Application No: AW/353/20/OUT
Site Address: Land adjacent to 1 Cambridge Walk Aldwick PO21 5RL
Description of works: Outline application with some matters reserved for 1 No. new dwelling.

Thank you for your internet representation made on 10th March 2021 which has been recorded as an objection with the comments as follows:

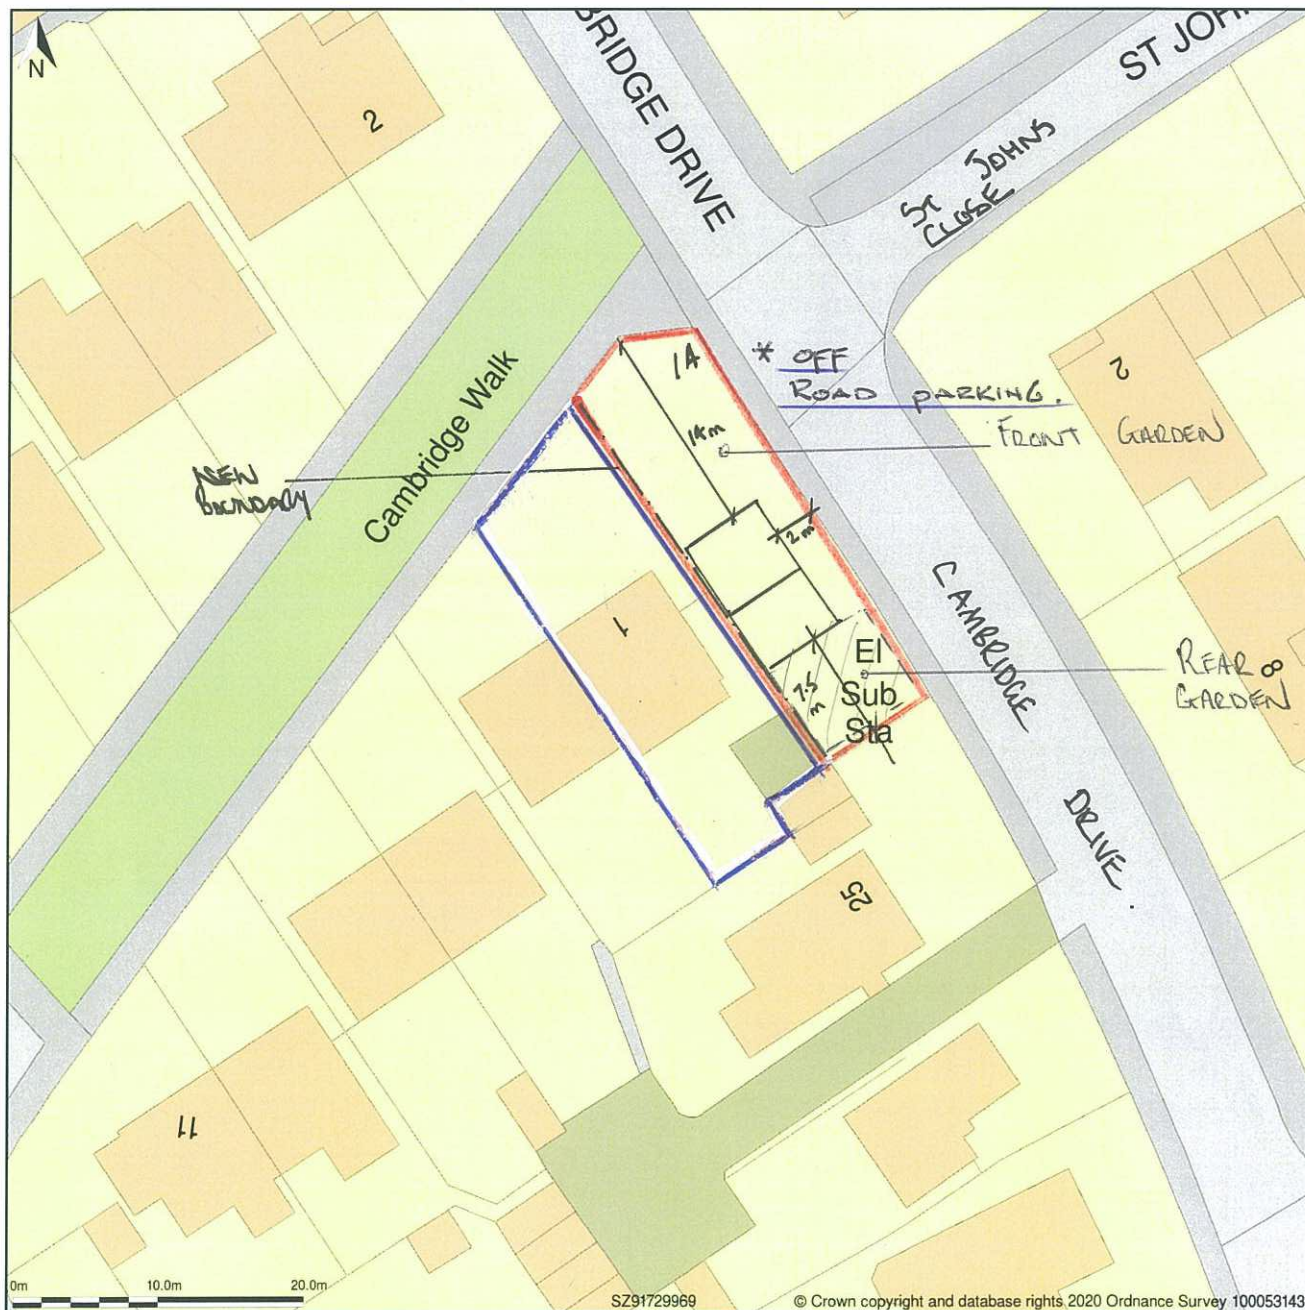
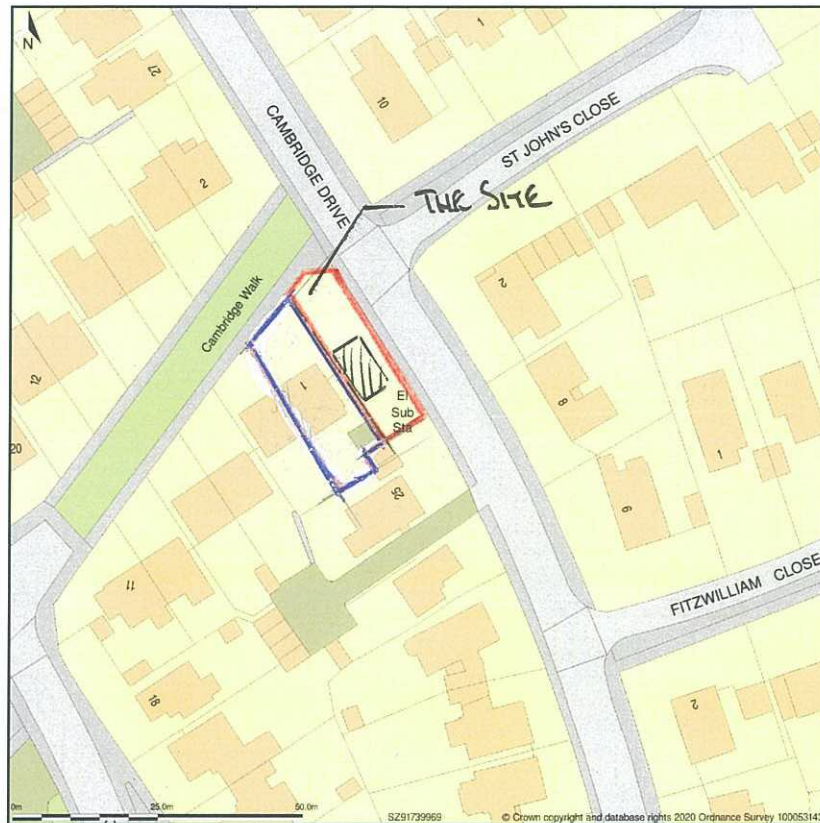
The proposed detached two bedroom dwelling & 6ft high boundary fence by reason of size height and prominent positioning well forward of the established building line in Cambridge Drive, would be very intrusive in the street scene and seriously detrimental to visual amenity and the open plan character of West Meads. Further, it would be contrary to the requirements and conditions of the planning permission granted in the 1960's for this open plan estate.
